A585 Windy Harbour to Skippool Improvement Scheme

TR010035

7.11 Environmental Statement Changes and Corrections Document

May 2019

APPENDIX C – Updated Figure 9.10 Photomontage at viewpoint location 2, view from residential properties on Breck Road, Photomontage at Viewpoint Location 9, view from Footpath 5-11-FP 2 at Junction with A585 Garstang New Road and Photomontage at viewpoint location 10, view from the B5260 Lodge Lane

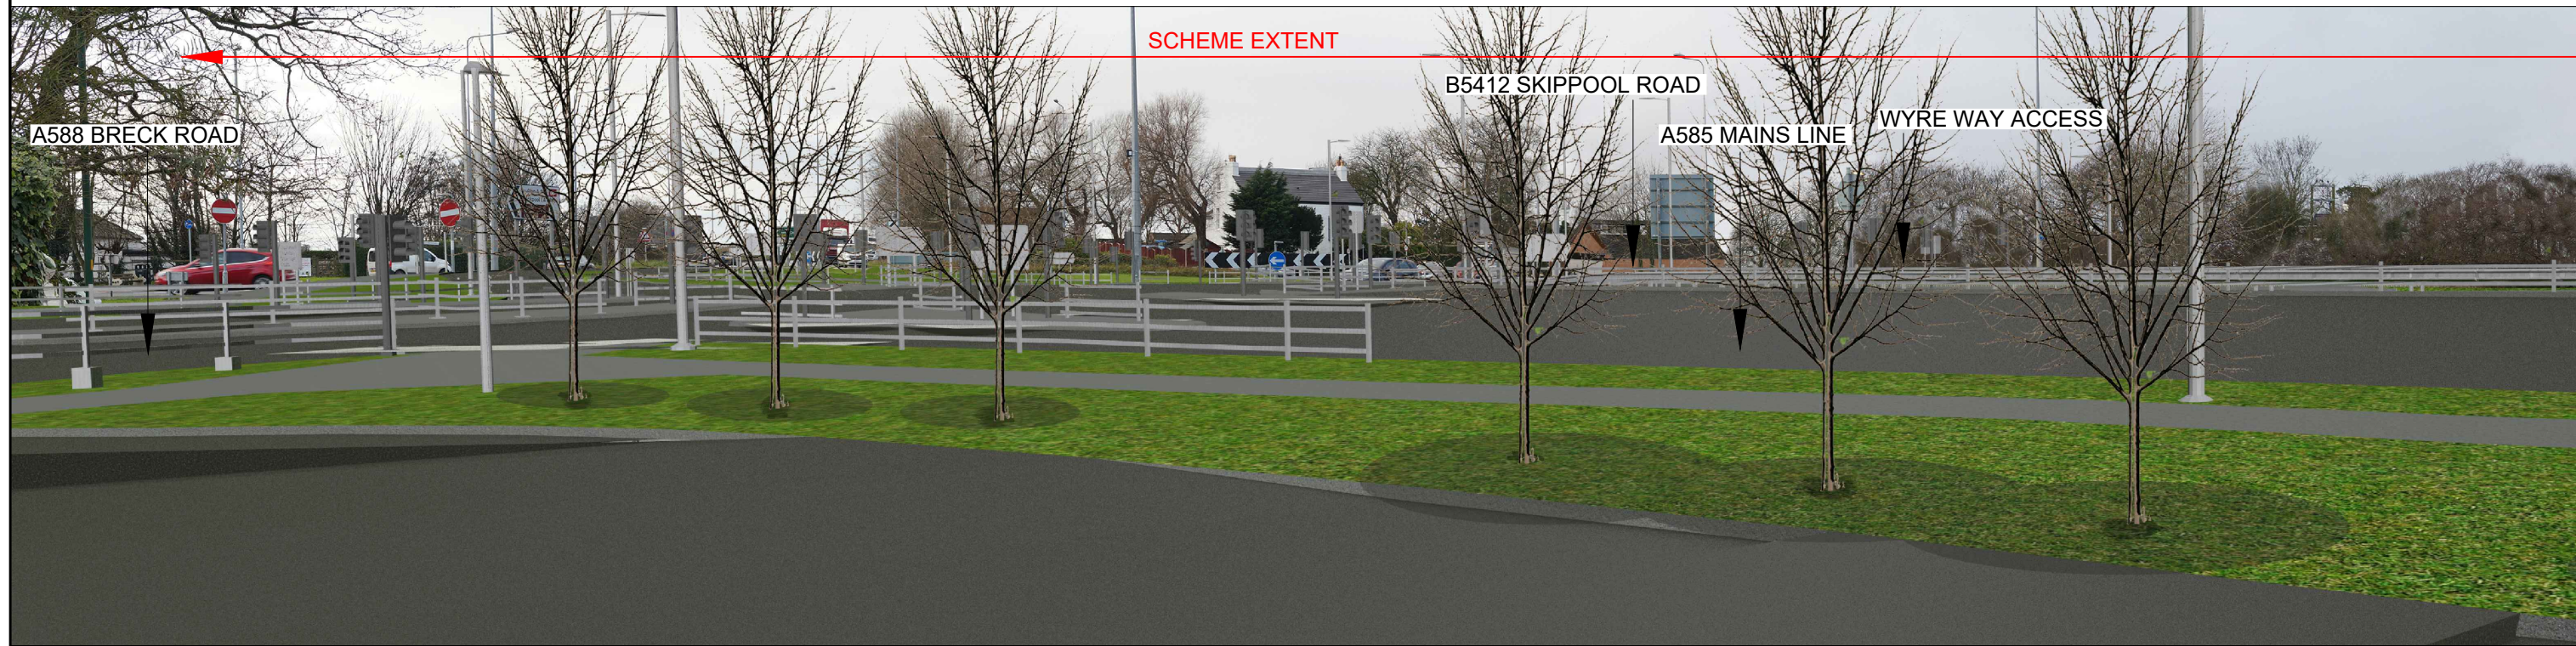
6.9	ES Chapter 9: Landscape	Update to Figure 9.10, Photomontage at viewpoint location 2, view from residential properties on Breck Road provided within Appendix C.	As a result of updates to the Flood Risk Assessment associated with the dwarf wall.

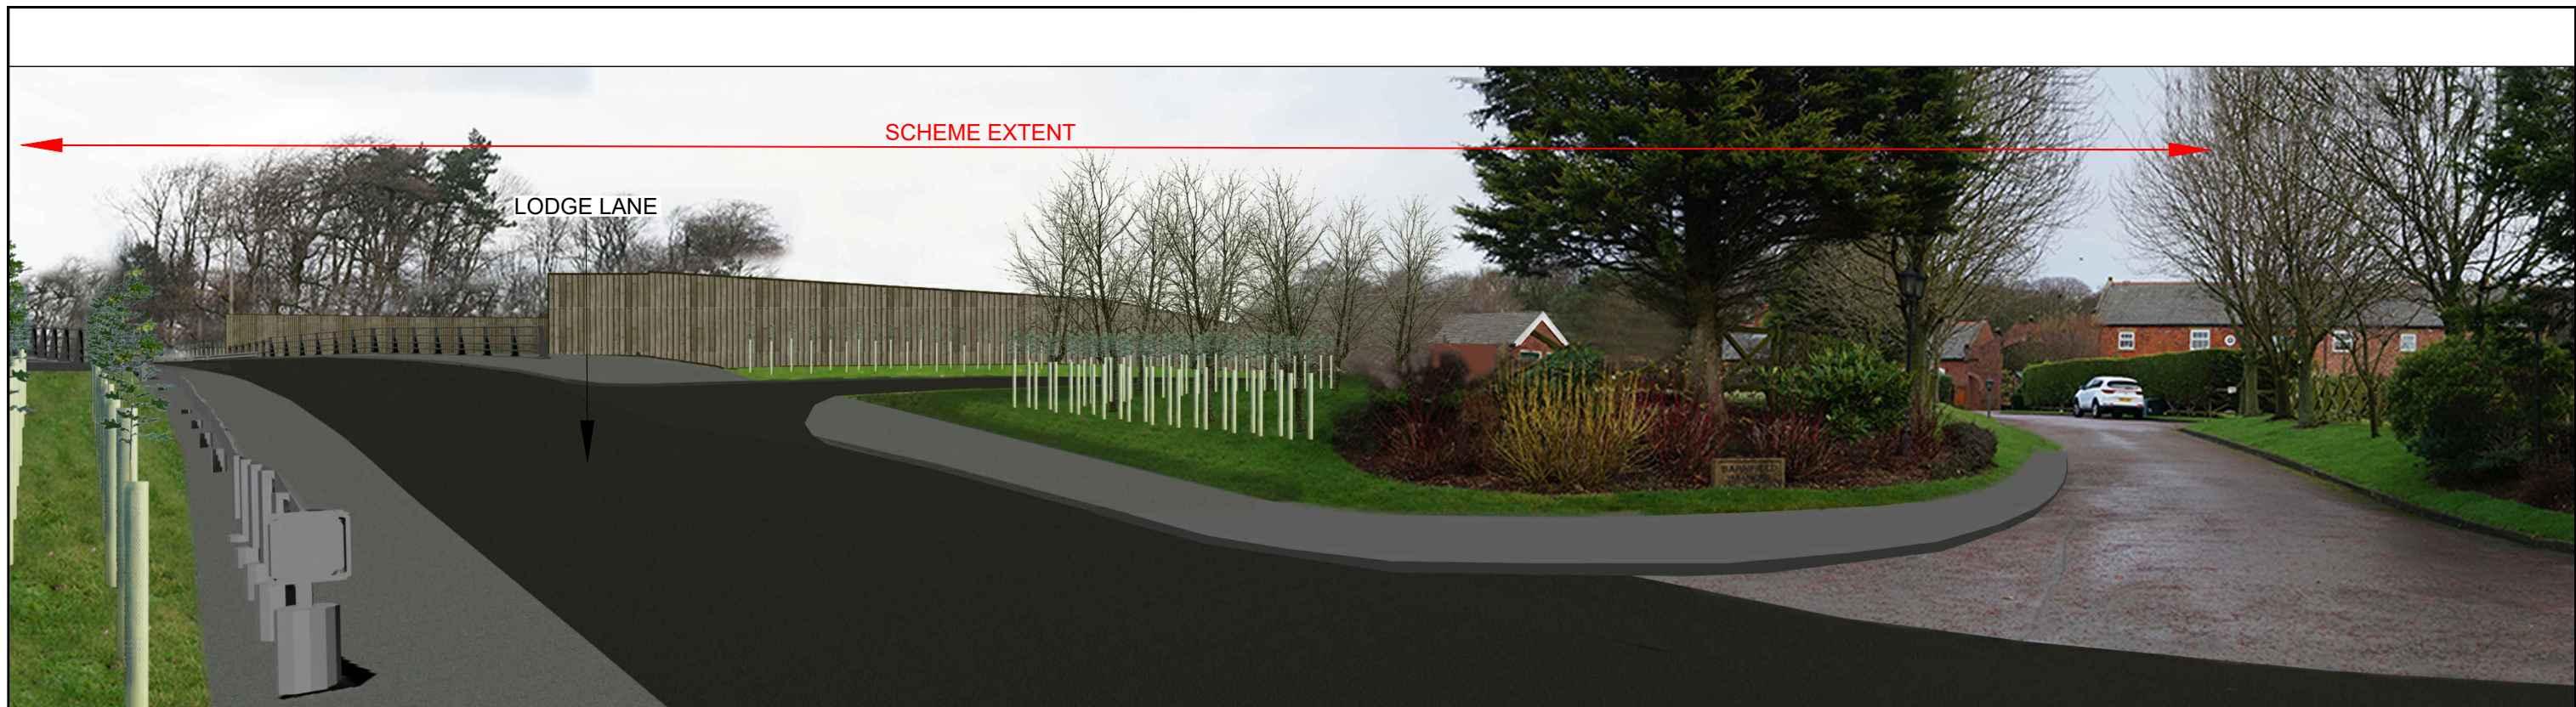
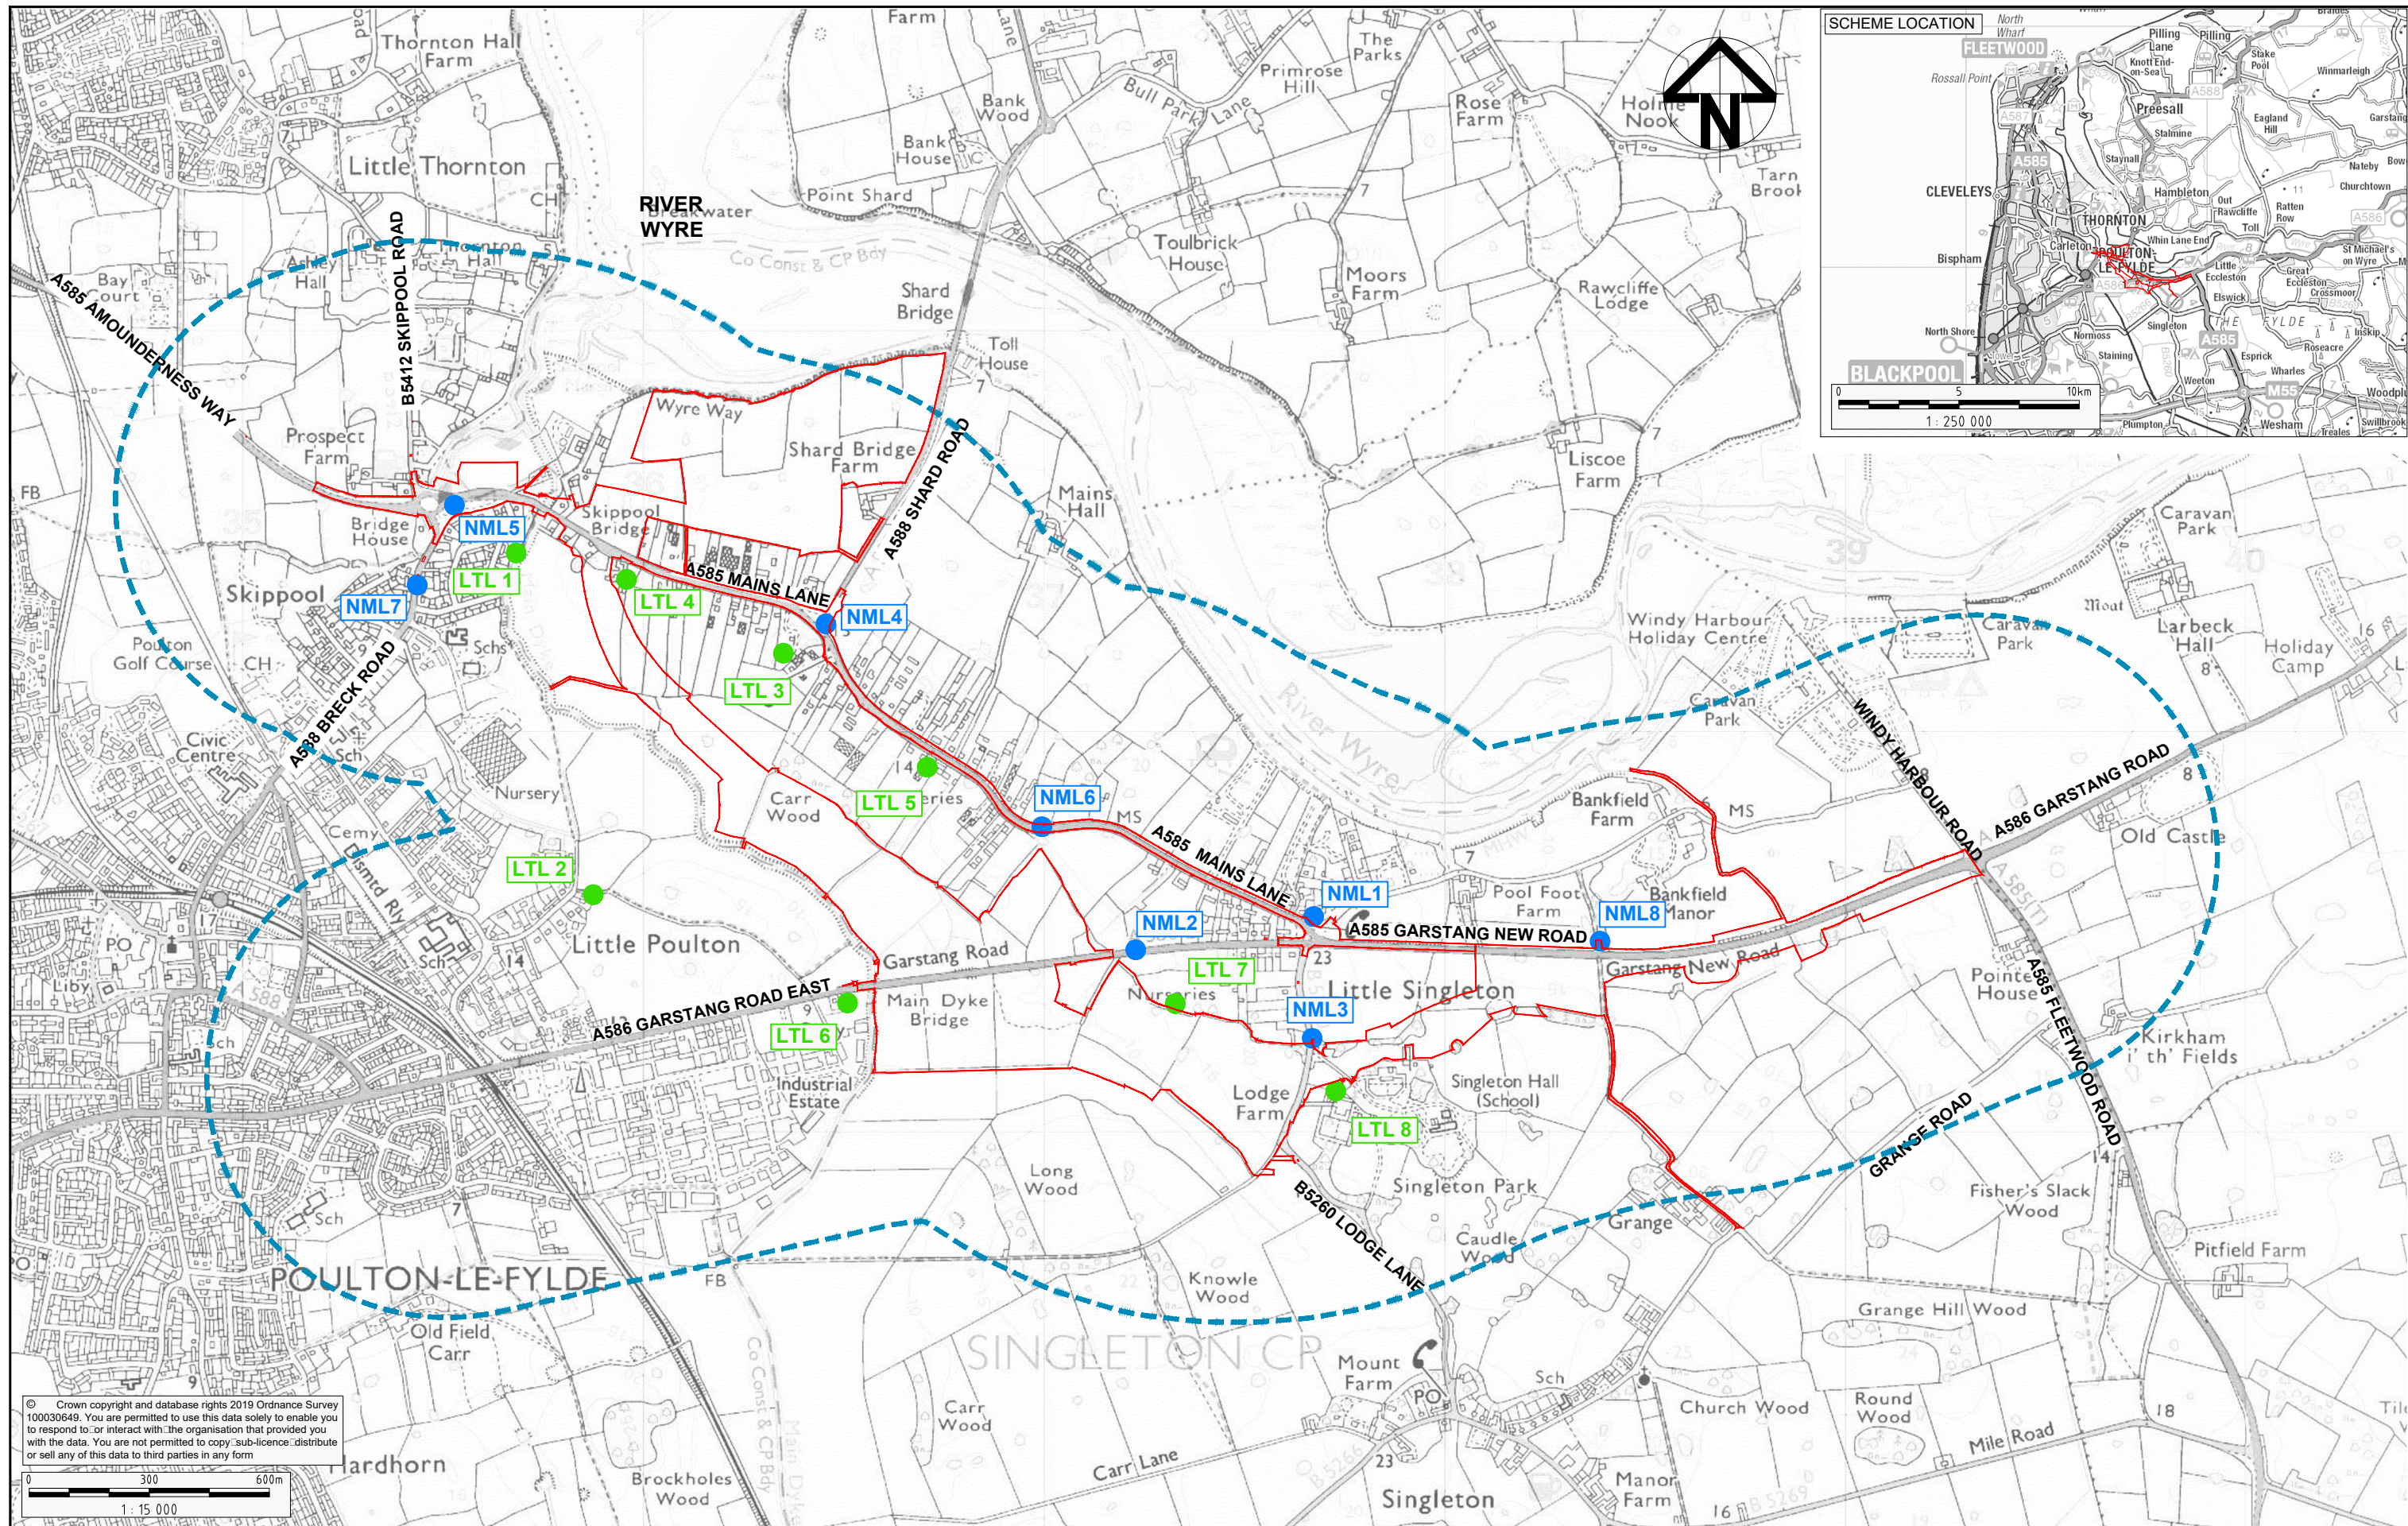
6.9	ES Chapter 9: Landscape	Update to Figure 9.10, Photomontage at viewpoint location 10, view from the B5260 Lodge Lane provided within Appendix C.	Updated to show the 3m high acoustic barrier to the north of the cutting.

Status	DEADLINE 2 SUBMISSION	Revision
Scale	1:15 000 A3	1
Drawn By	J.NORMAN	Date
Checked By	K.BURROWS	MAY 2019
Approved By	N.HENDERSON	
PINS No.	TR010035	FIGURE 11.1
Drawing number	HE548643-ARC-EGN-SZ_ZZ_000-DR-LE-30

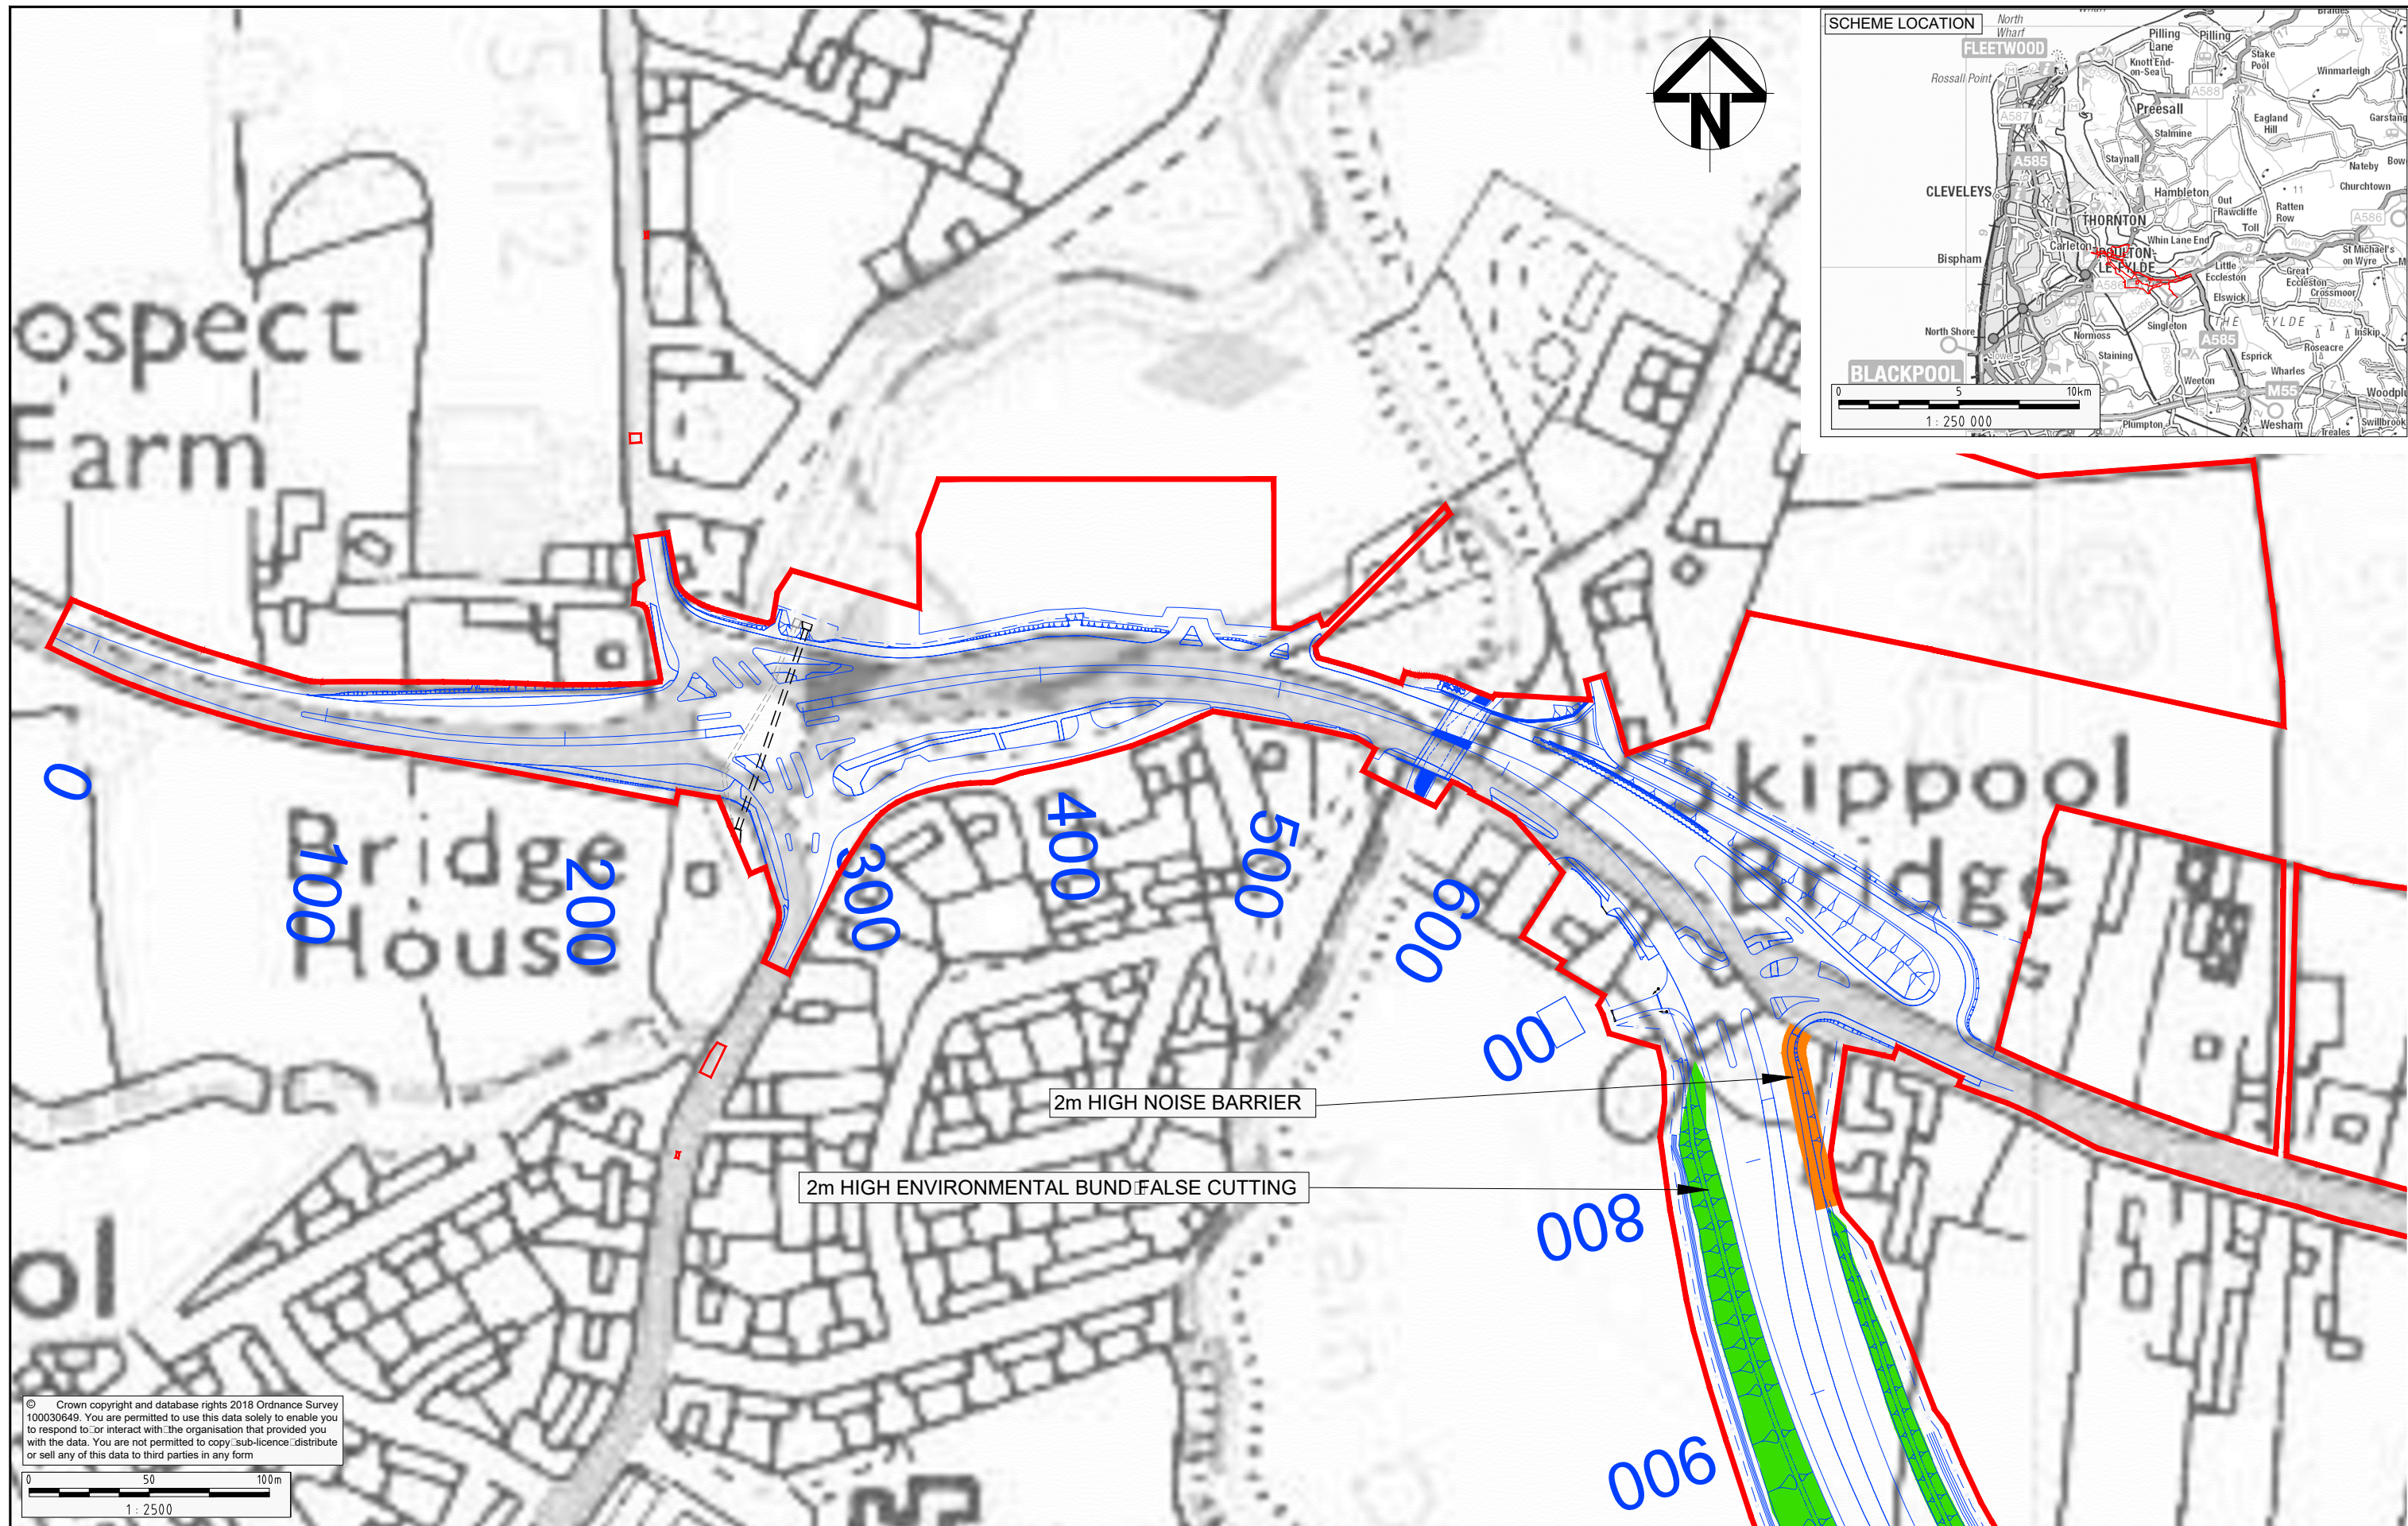
6.11	ES Chapter 11: Noise and Vibration	Update to Figure 11.1: Noise and Vibration – Noise Monitoring within the Study Area presented at Appendix D to show the locations of the eight attended noise surveys.	Requested by the Inspector within the first round of written questions (document reference TR010035/APP/7.10).
